Planning Application Ref: WA/117/21/T

Location: Mulberry Barn, Eastergate Lane, Walberton, BN18 0BA

Description of works: Mature English oak (T1) - Crown lift the low southerly growth to allow 2m between the tree and roof line of Mulberry Barns and remove some of major dead wood where it is a risk to the roof and public

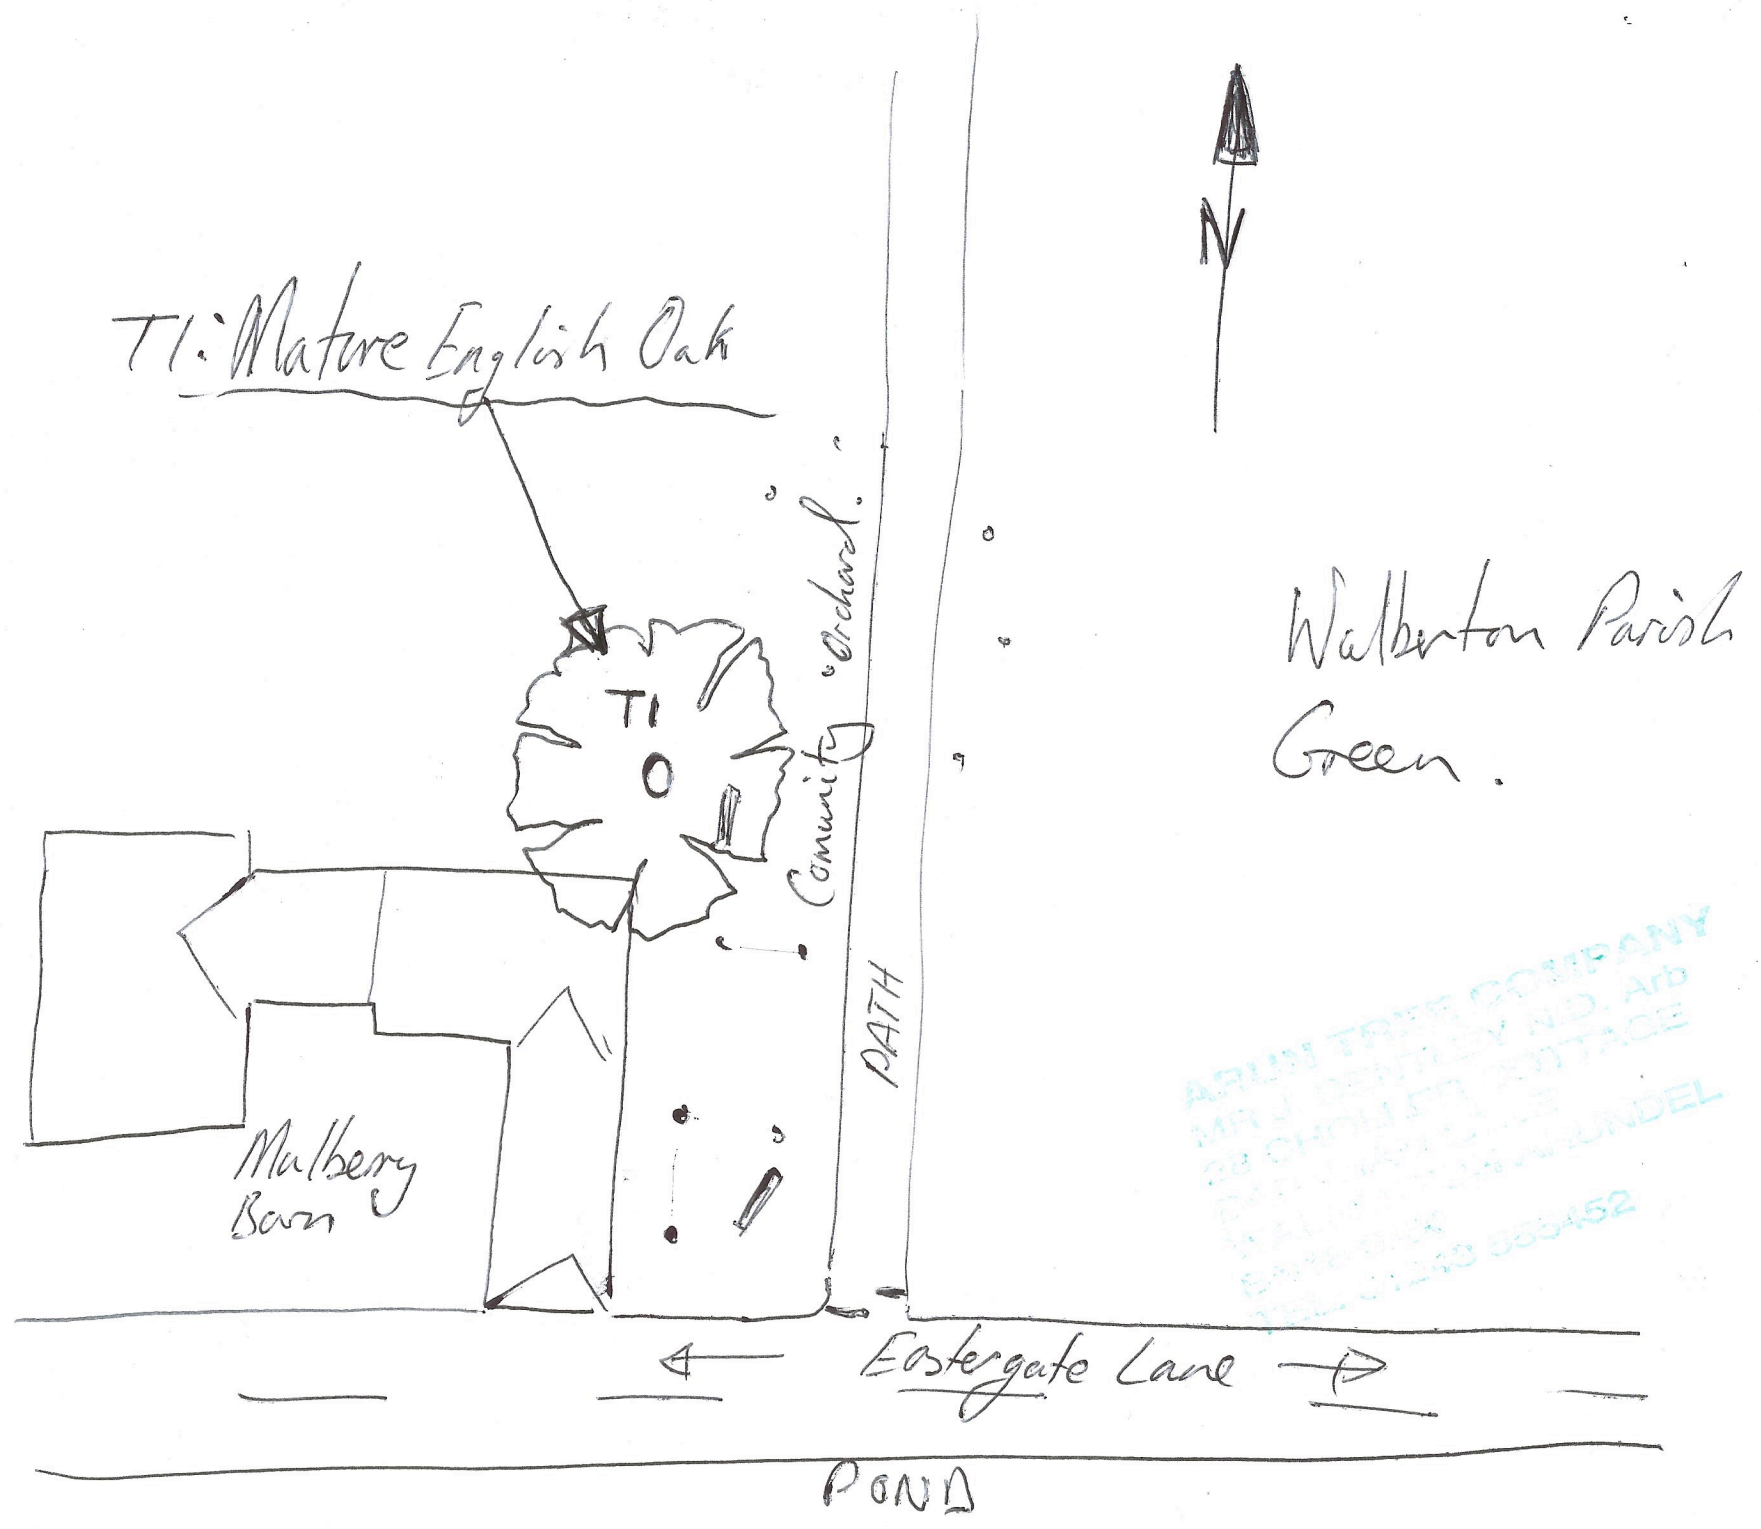
- The applicant has employed Arun Tree Company Ltd. to assess the tree and provide a report on its condition, which recommends a balanced work proposal to manage the tree in an appropriate state for its location.
- This is a long-established tree of apparent good health albeit with a heavily modified crown. It is visible from numerous properties and to users of public open space and highway (footway and carriageway).
- The removal of dead branches is an exception and does not require permission from the local planning authority.

- I recommend **CONSENT** for this application, subject to the following condition:

Part a) Where whole branches are to be removed and final cuts made close to the trunk or branch union they are to be made as shown in Figure 2 of BS3998:2010

Part b) Where branches are to be shortened back the final cuts are to be made at the correct angle shown in BS3998:2010 and adjacent to a live bud or lateral.

Part c) Where pollarding or crown reduction pruning has occurred previously, then the removal of crown material which has developed since the last operation must be done sympathetically and with respect to established 'knuckles' so as not to extend beyond the point of origin.
